P428 Vary B Responses To Comments April 2010

Response to Government Department Comments.
7 Parkview Drive, Sydney Olympic Park

1. SDRCA/RTA Letter – dated 16th March 2010

2 Basement 01
1:500

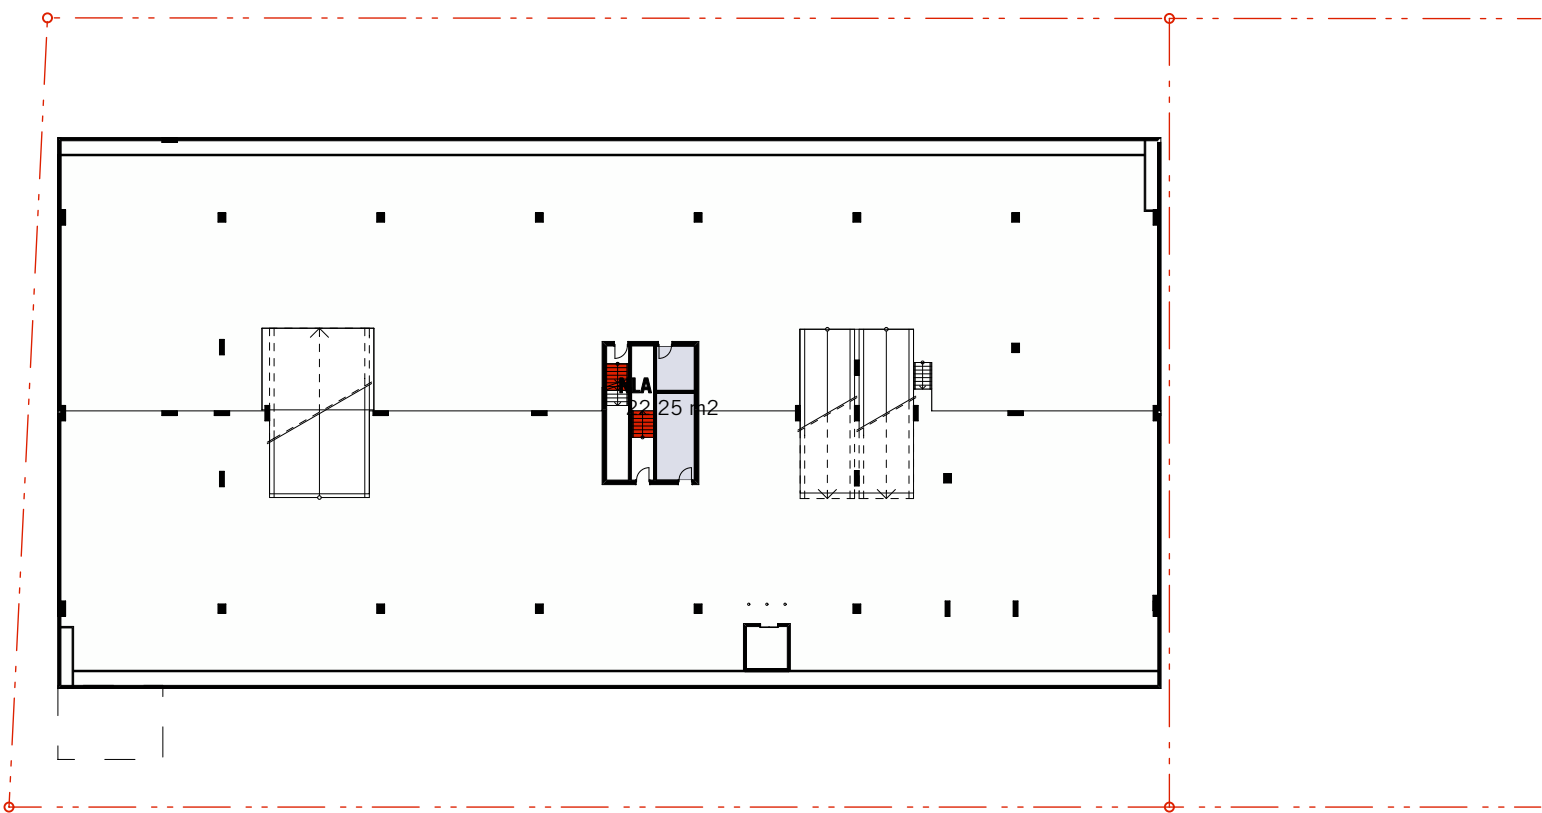
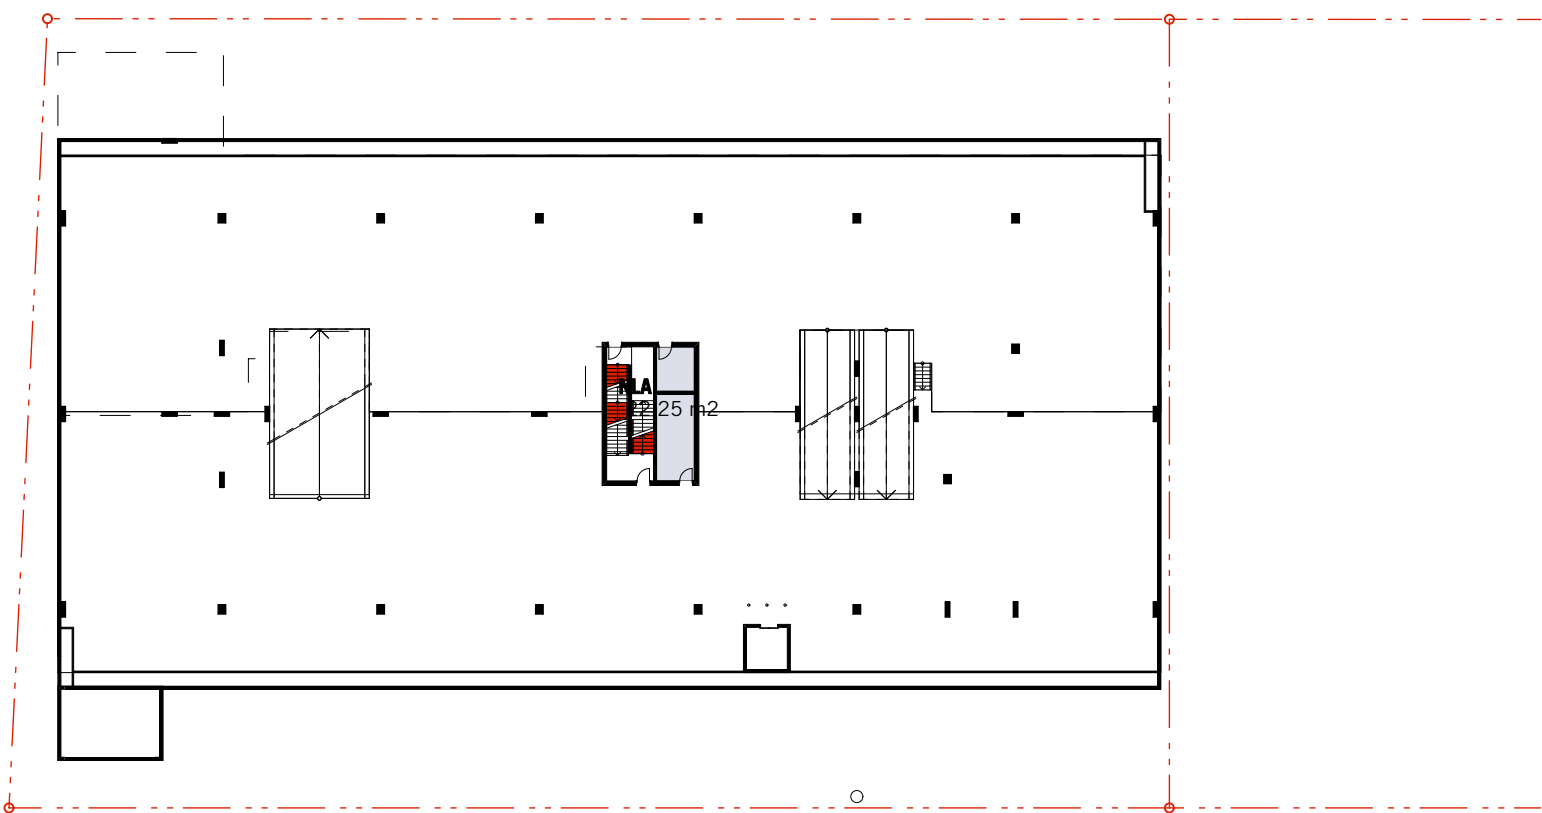
Item 3 – Issue – *Parking Layout in accordance with Australian Standards*. This is noted and will be addressed in the detail design phase of the project, however, as stated in Section 5.3.2 and 5.3.3 of the Transport and Access Study, the submitted car park design conforms to AS2890.1.2004 in all aspects except for the length of the queuing area on the approach to the car park entry. Whereas 5 car lengths are specified by AS 2890.1.2004, only 3 off road spaces can be provided. It is not proposed any commercial vehicles will use the car park for access therefore it does not need to conform to AS 2890.2002. All commercial access is via the loading dock.

Item 4 – Issue – *Speed humps in car park*. The longest aisle length is 75m (between ramps 35-40m for horizontal circulation) and does not justify the use of speed humps in the car park. The car park will be signposted as a 15kph zone.

Item 5 – Issue - *Aisles to be marked with arrows*. Adequate directional signage will be provided, including pavement arrows where appropriate.

Item 7 – Issue – *Vehicles wholly within site*. The entry barriers are located 7m inside the site property boundary, therefore a vehicle can queue at the barrier and be wholly contained within the site. The entry system of key fob control of the barrier gates will ensure fast entry to the car park.

4 Upper Ground Level
1:500

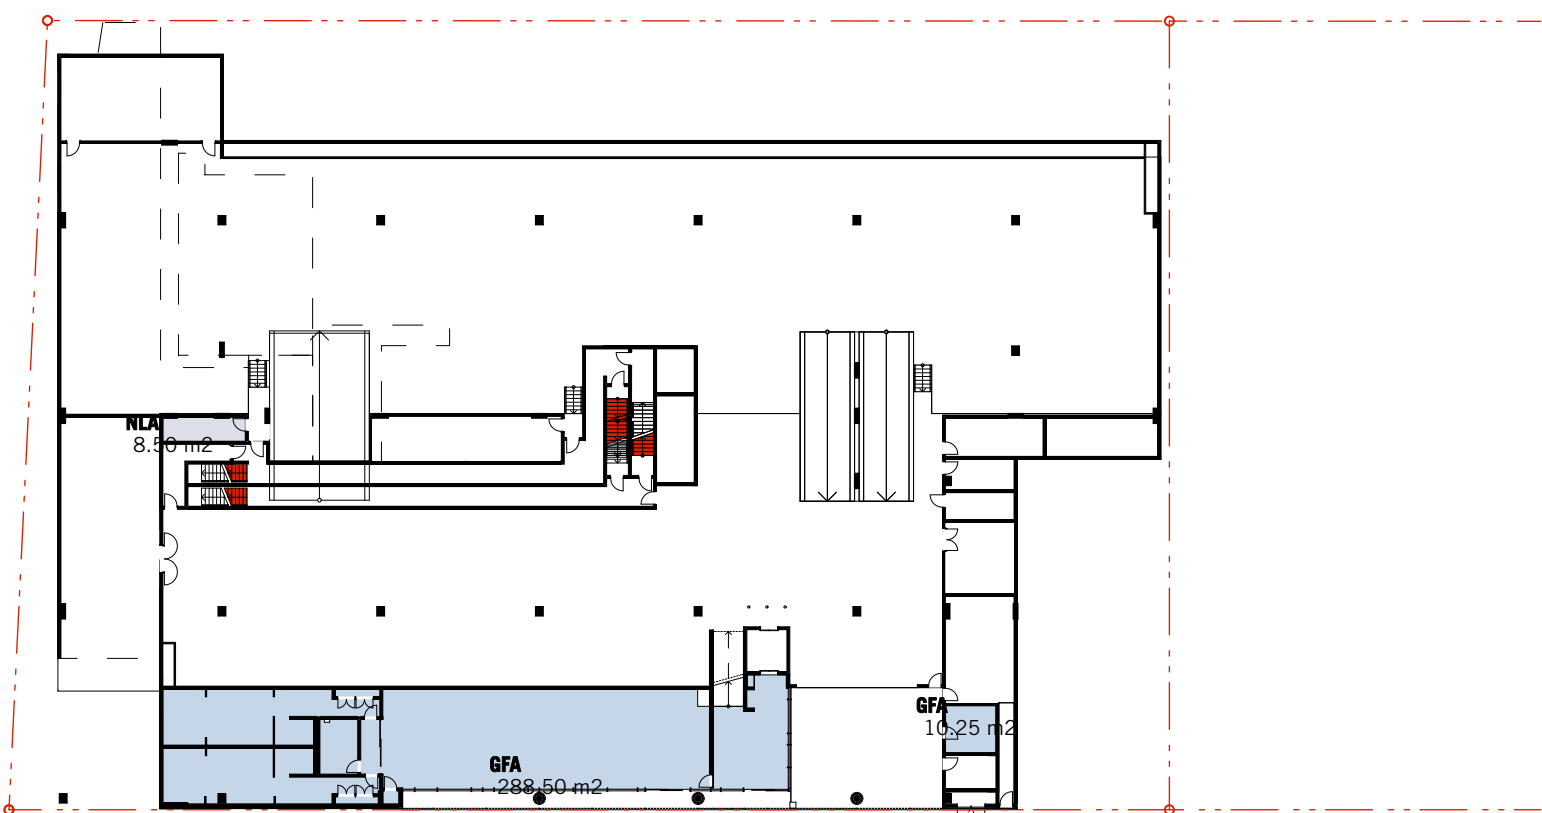
Item 8 – Issue – *Swept path of longest vehicle likely to use the site be accounted for*. Noted. The loading bay has been designed to accommodate an 8.8m rigid axle (AS Standard MRV swept path) rubbish truck. It is expected all other general loading dock movements will be in smaller vans and trucks. There will be no commercial vehicle access into the car park.
